**Re: U-Haul at 8200 Jefferson St. NE
Erosion and Sediment Control Plan – C17E146 – (SWQ-2025-00051)
Engineer's Stamp Date: missing**

Based on the information in your submittal received on 10/31/25, the ESC Plan and Notice of Intent (NOI) cannot be approved until the following comments are addressed.

James D. Hughes, P.E., CPESC
Principal Engineer, Planning Dept.
Development and Review Services

GRADING AND DRAINAGE PLAN

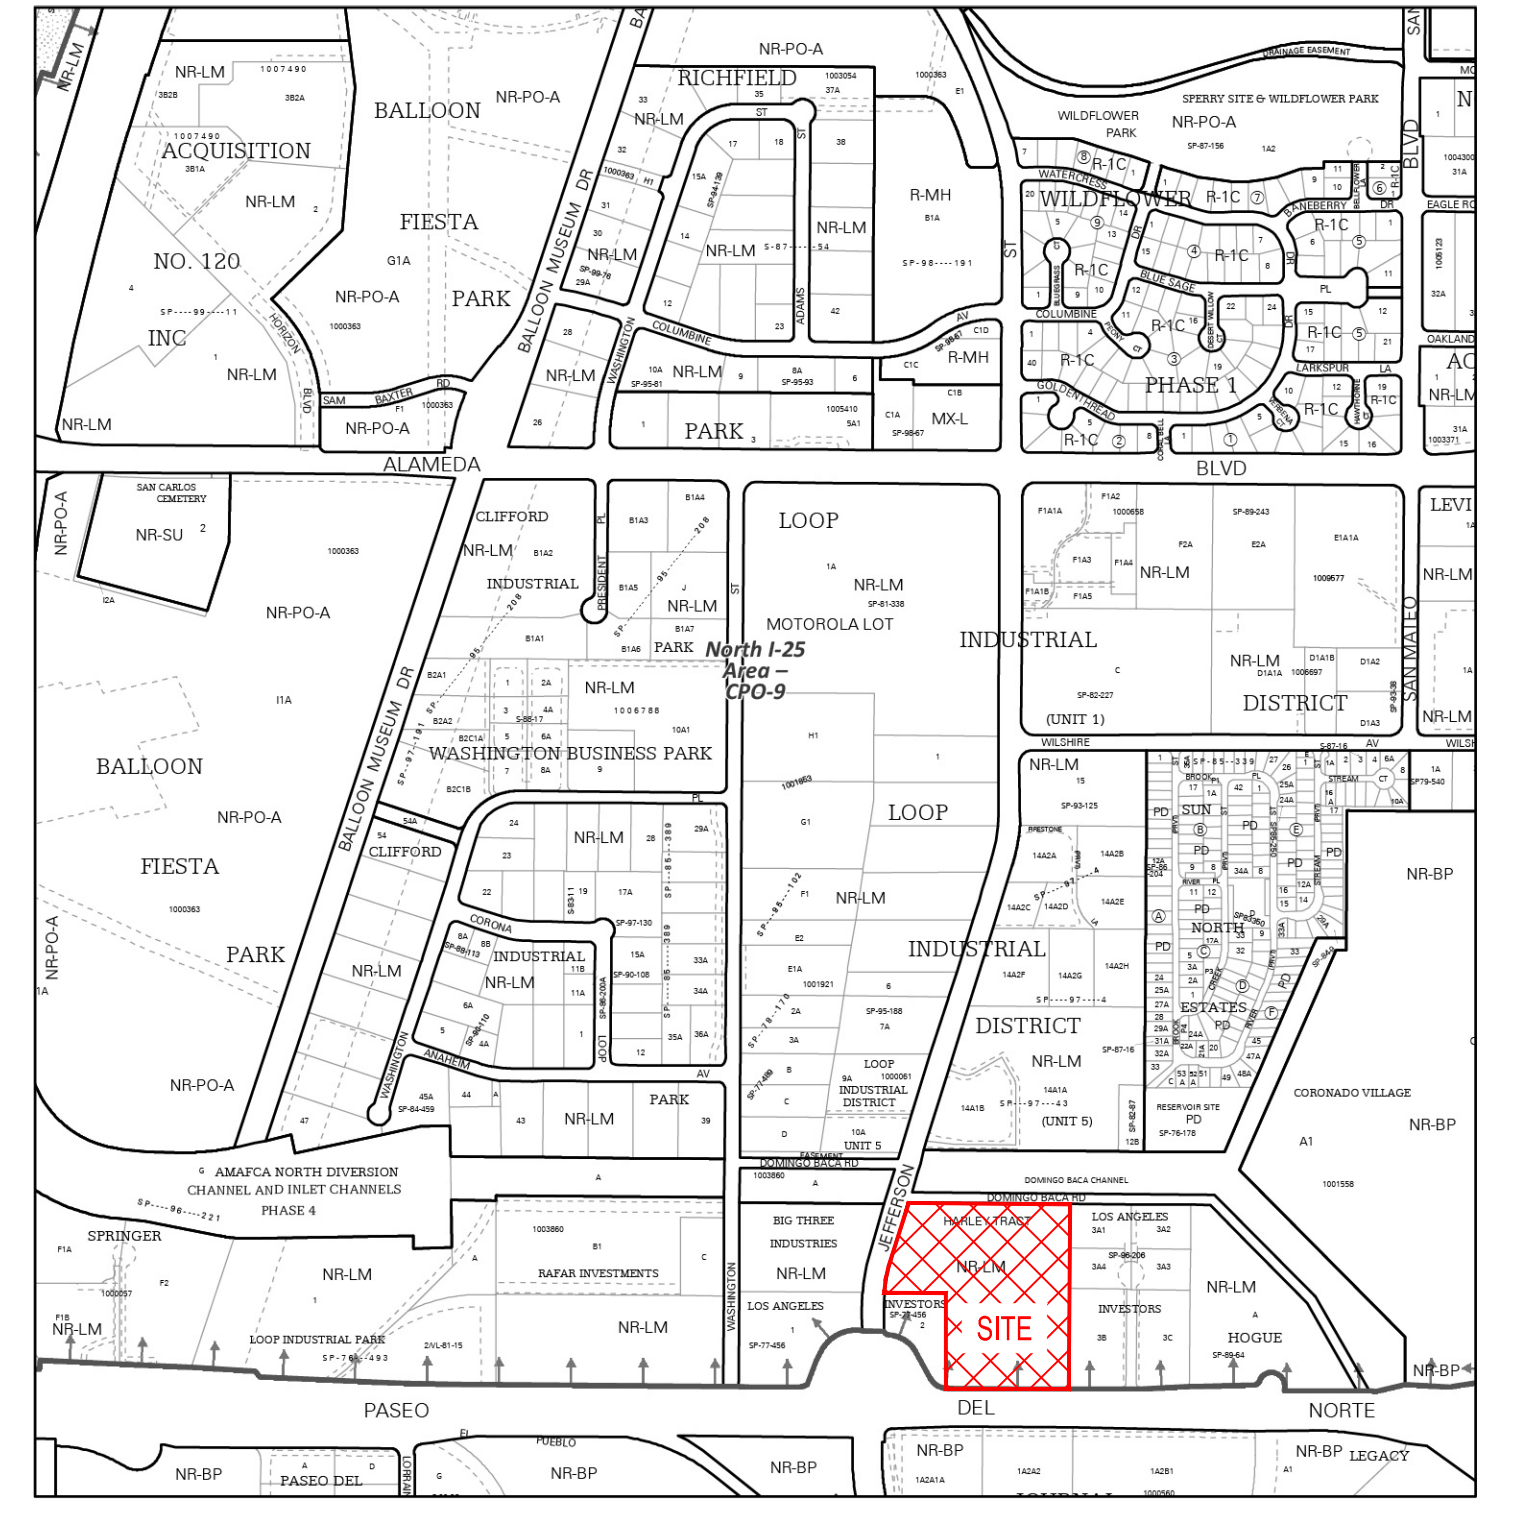
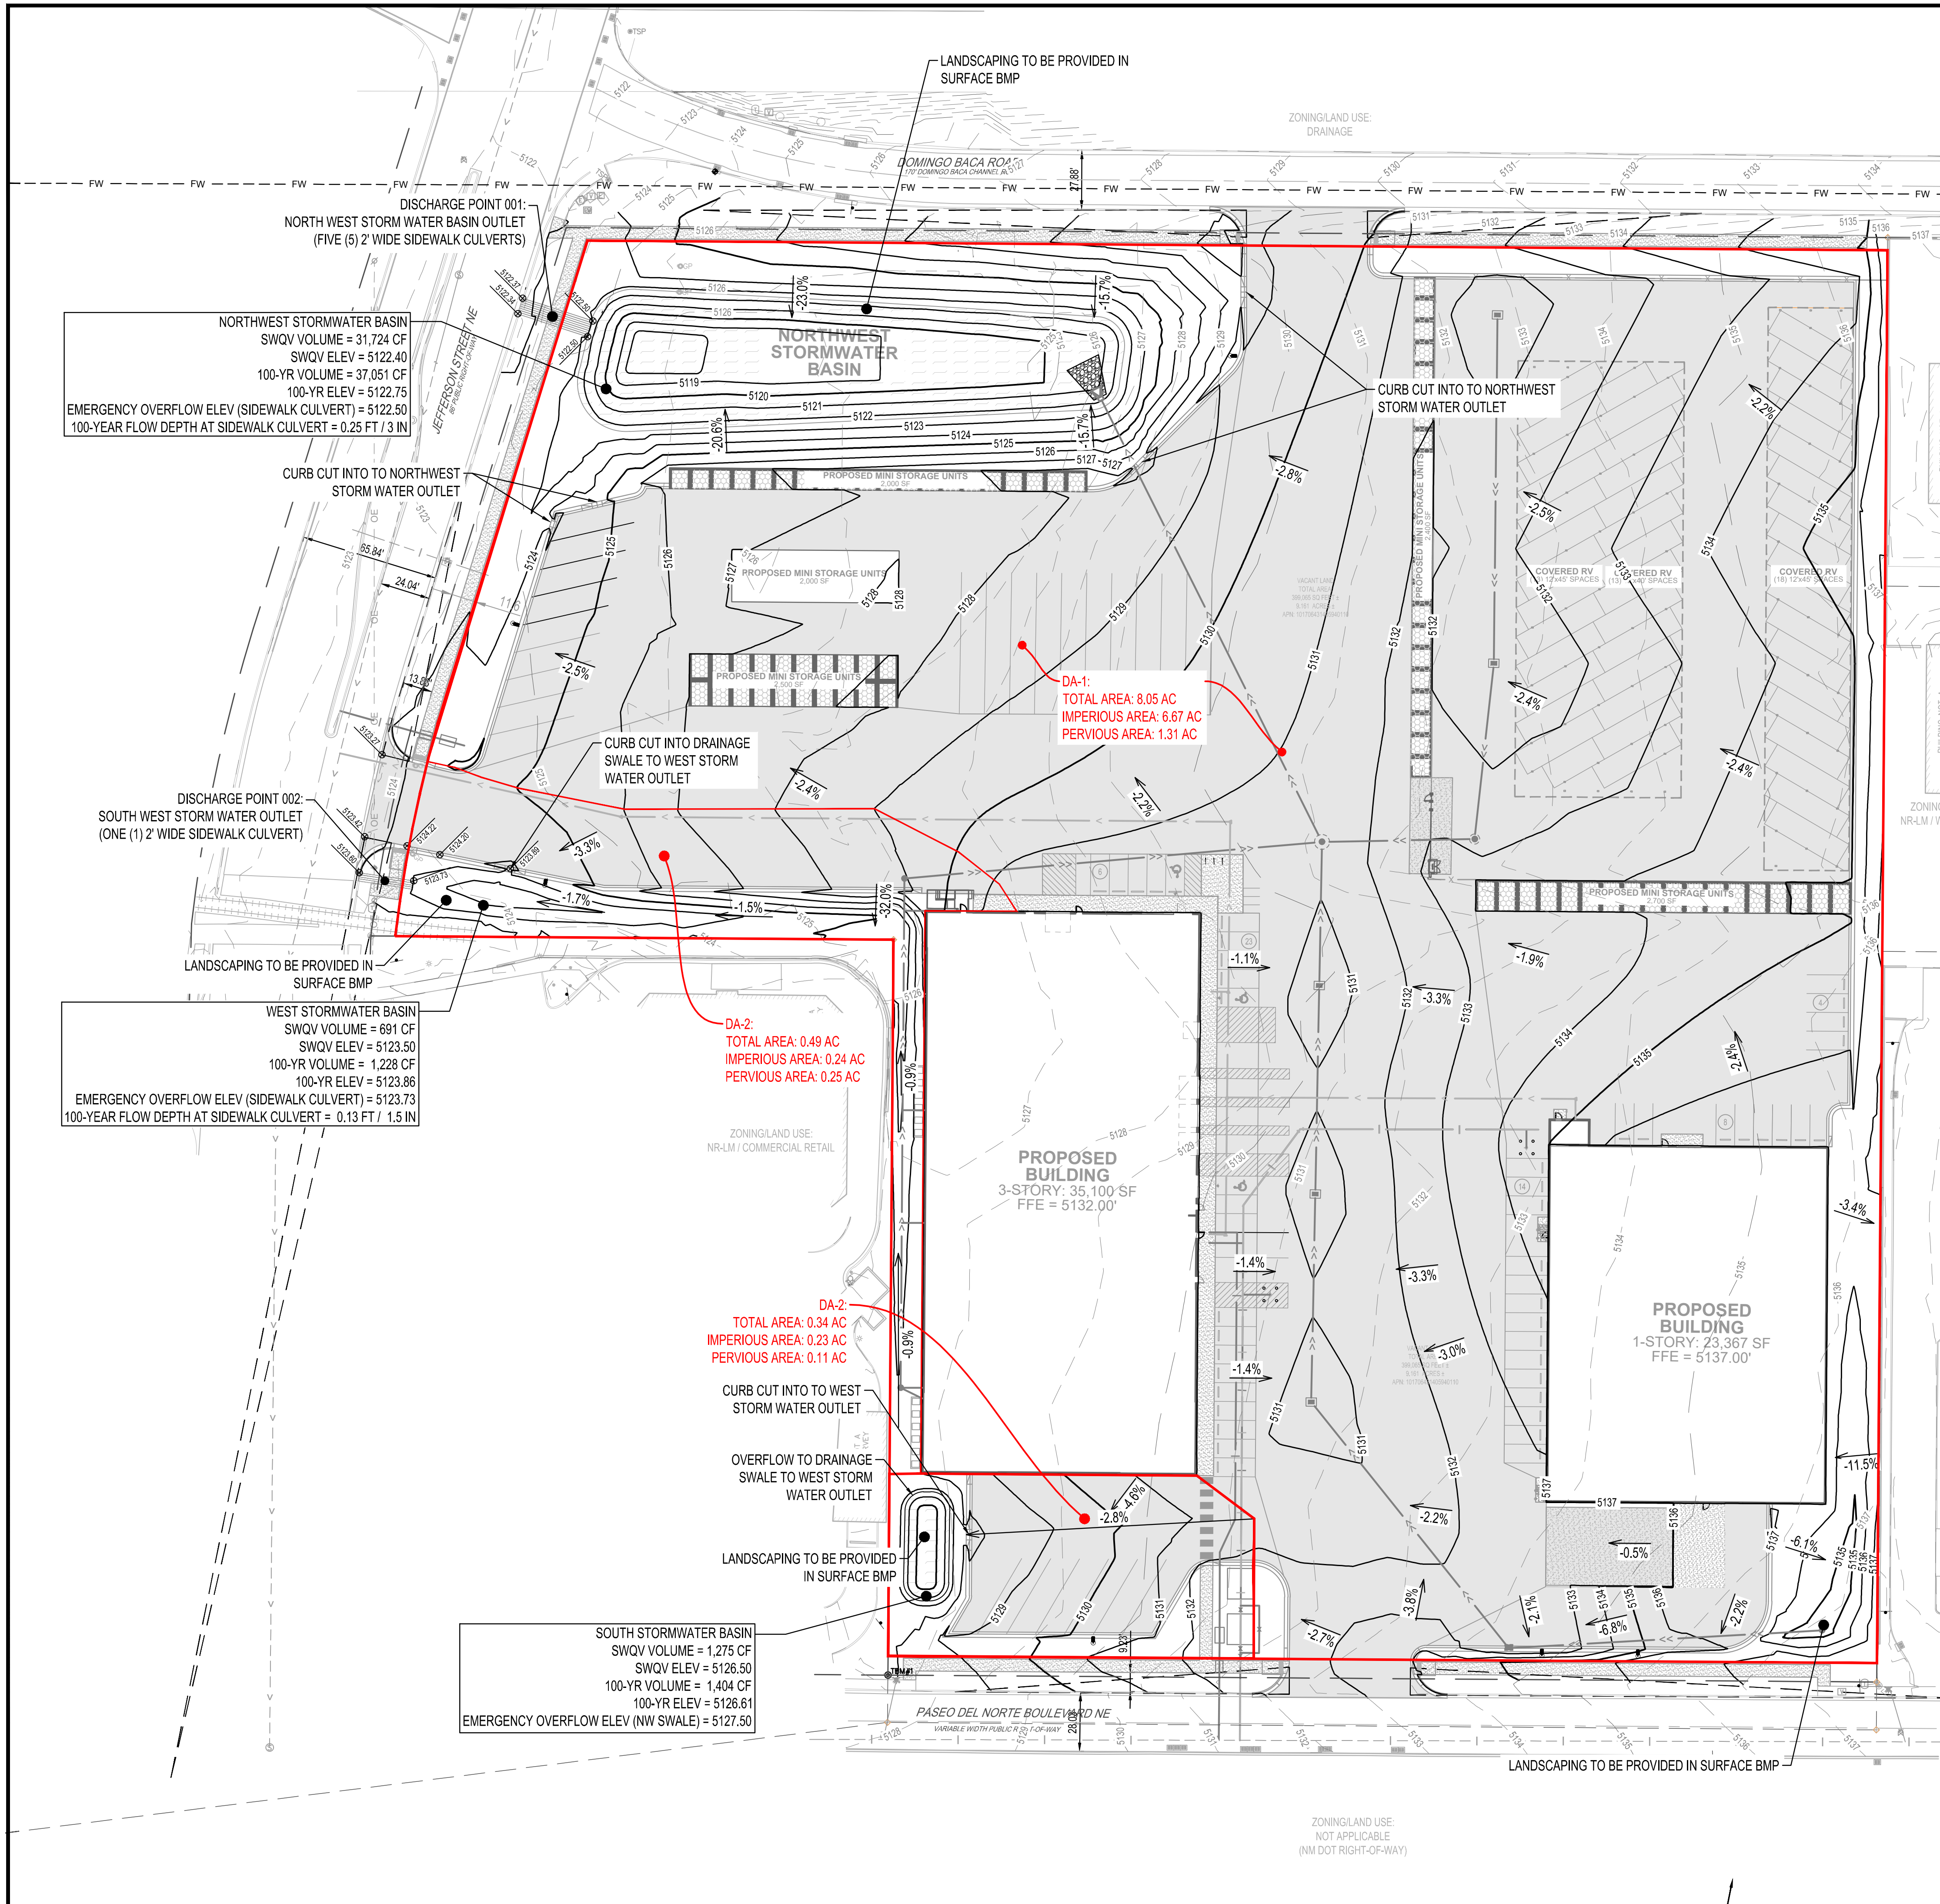
4. An Erosion and Sediment Control (ESC) Plan is required by City Ordinance § 14-5-2-12(G)(4), but it was missing from your submittal. Instead, a copy of the Grading and Drainage (G&D) Plan and Stormwater Management Reports was provided. These documents identified a 9.75-acre site, whereas the NOI specifies 8.75 acres. All land disturbance, including off-site frontage and construction support areas, must be included on the ESC Plan and NOI. The G&D Plan included post-construction SWQ ponds and calculations, rather than the required temporary construction SWQ ponds and calculations. An ESC Plan must be included with your resubmittal in ABQ-PLAN.
